Our ref: SSD 7155 MOD 2
File:17/02649

**Prestons Industrial Estate Project Section 96(1A) Modification (SSD 7155 MOD 2)
Response to Submissions**

ATTACHMENT 1

LANDSCAPE PLAN 01

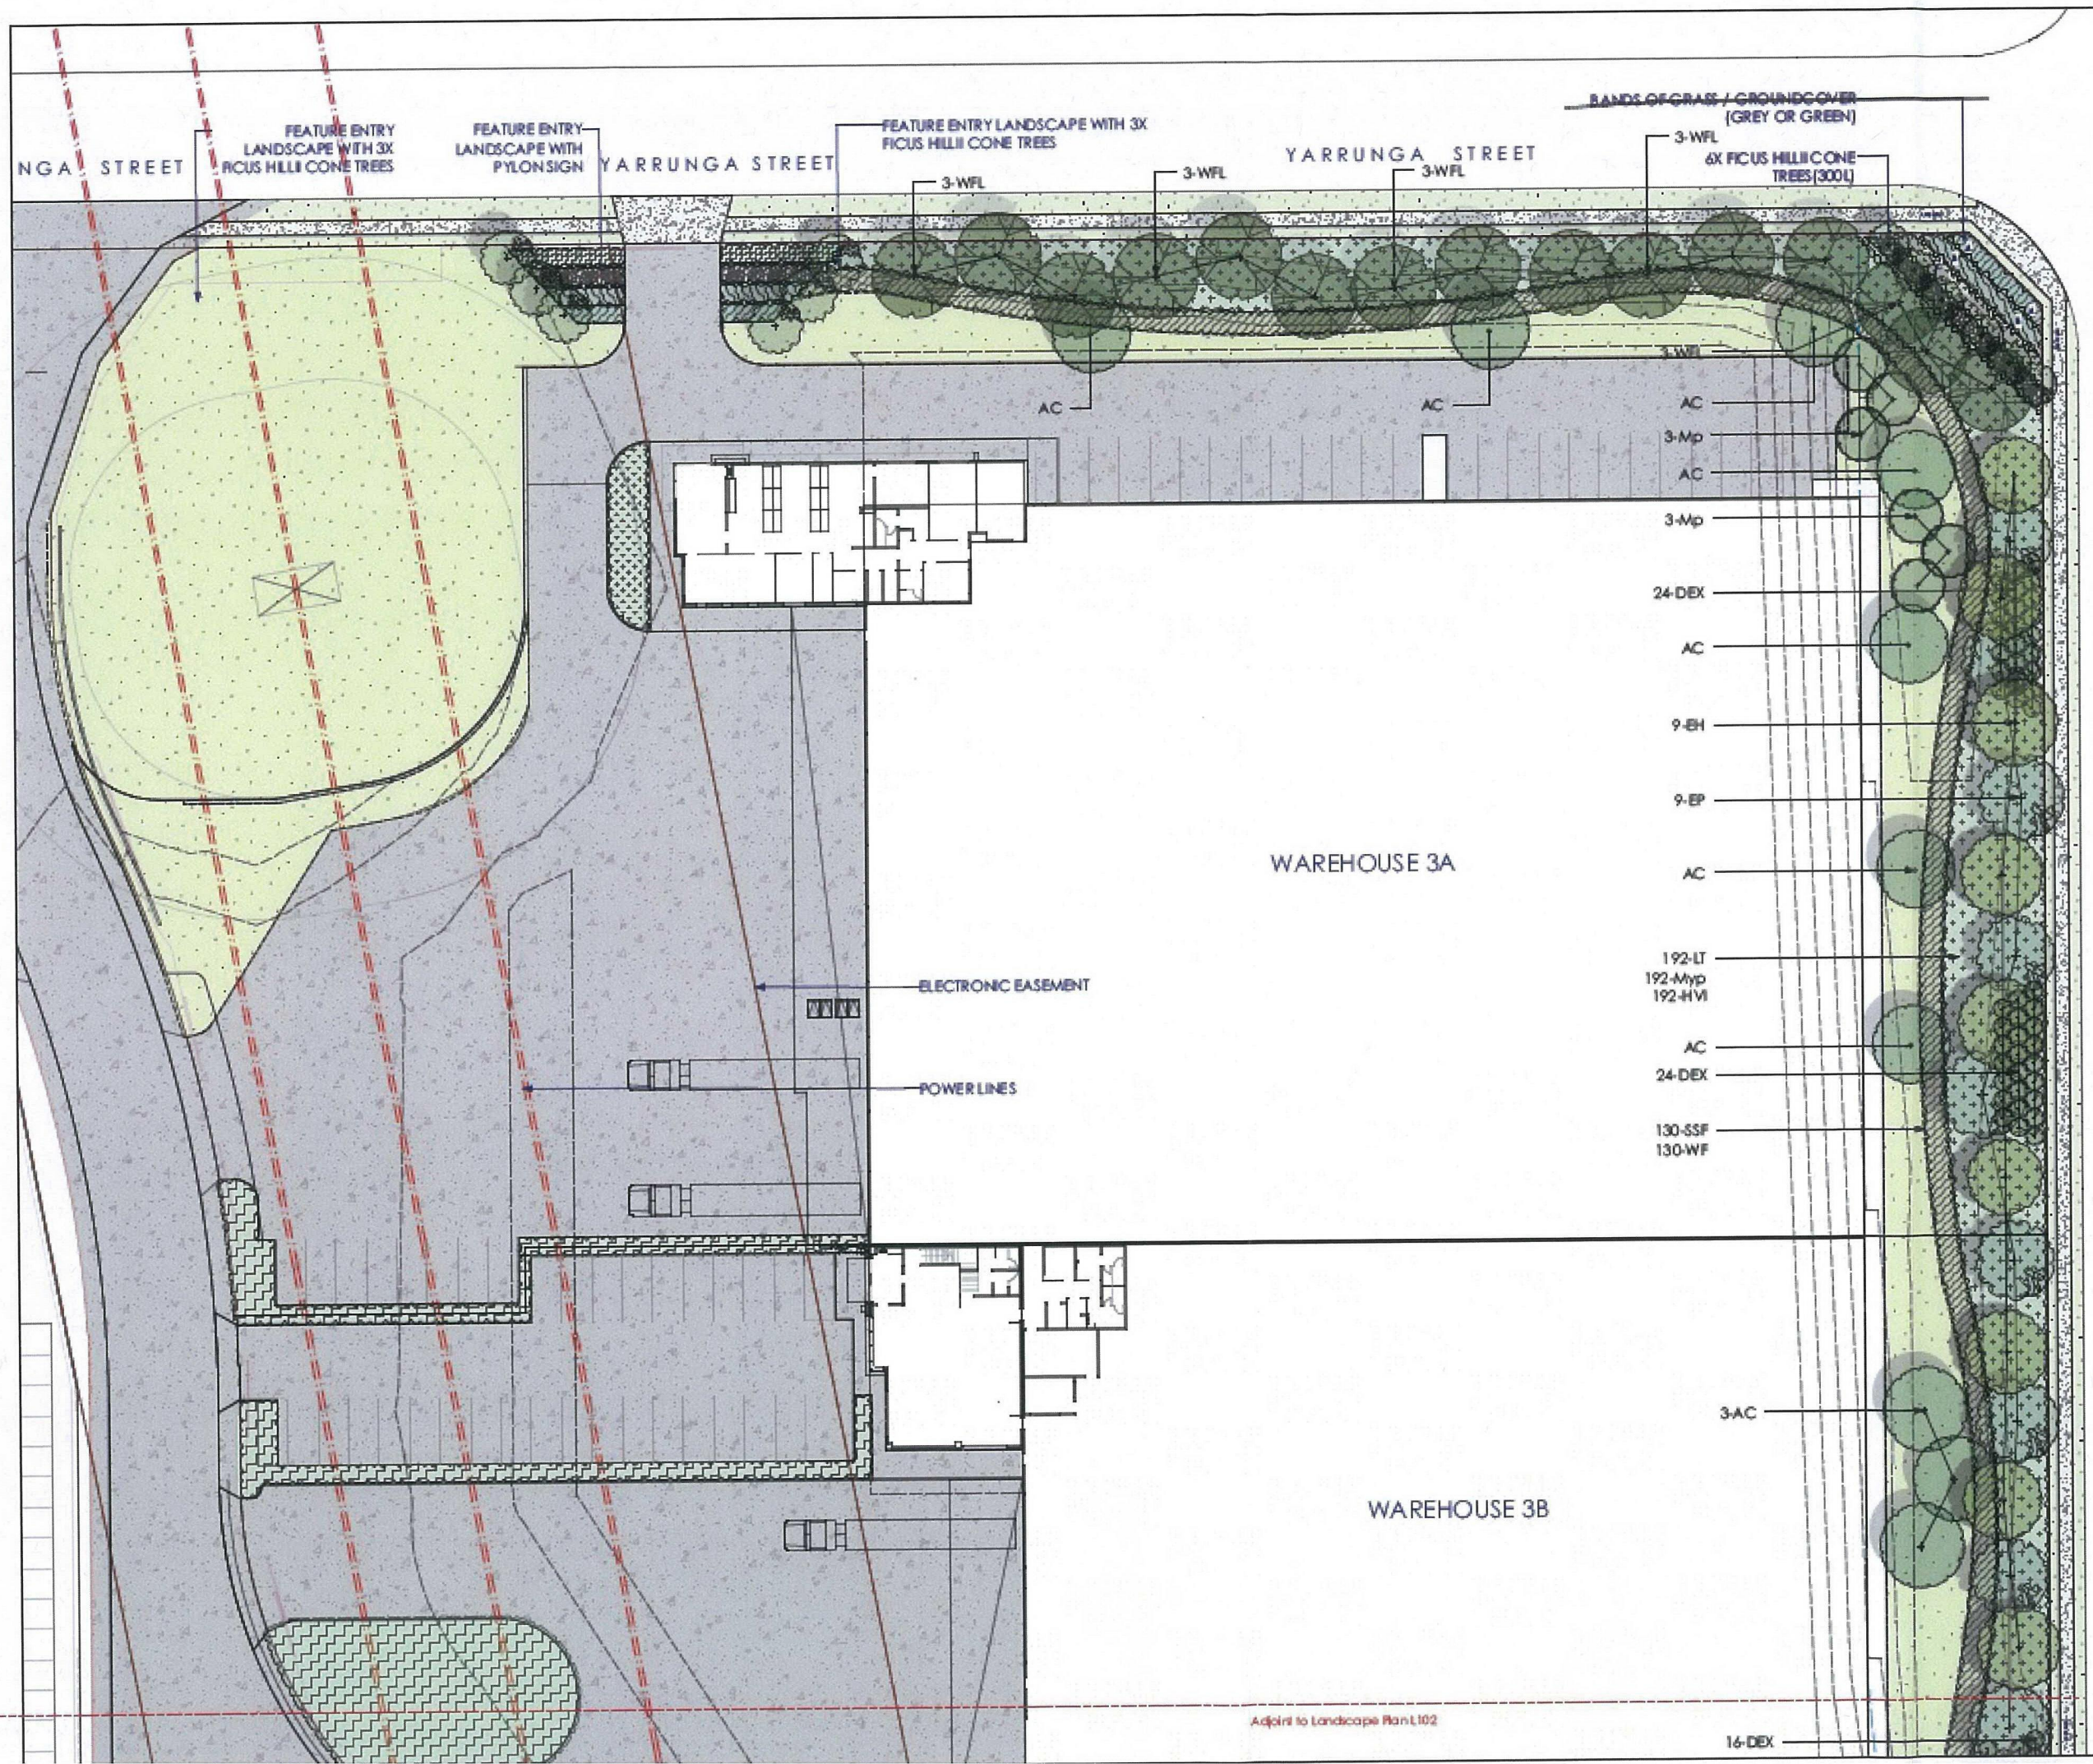
- It is noted the landscaping section adjacent to Warehouse 4 along Bernera Road will be reduced from 6 metres to 2 metres in width. Please provide a detailed plan of the proposed landscaping along the Bernera Road frontage of Warehouse 4 which shows the height of tree species to be planted along this frontage of the site. Please also provide justification for the reduction in landscaping and an assessment of visual impacts on the Bernera Road streetscape.
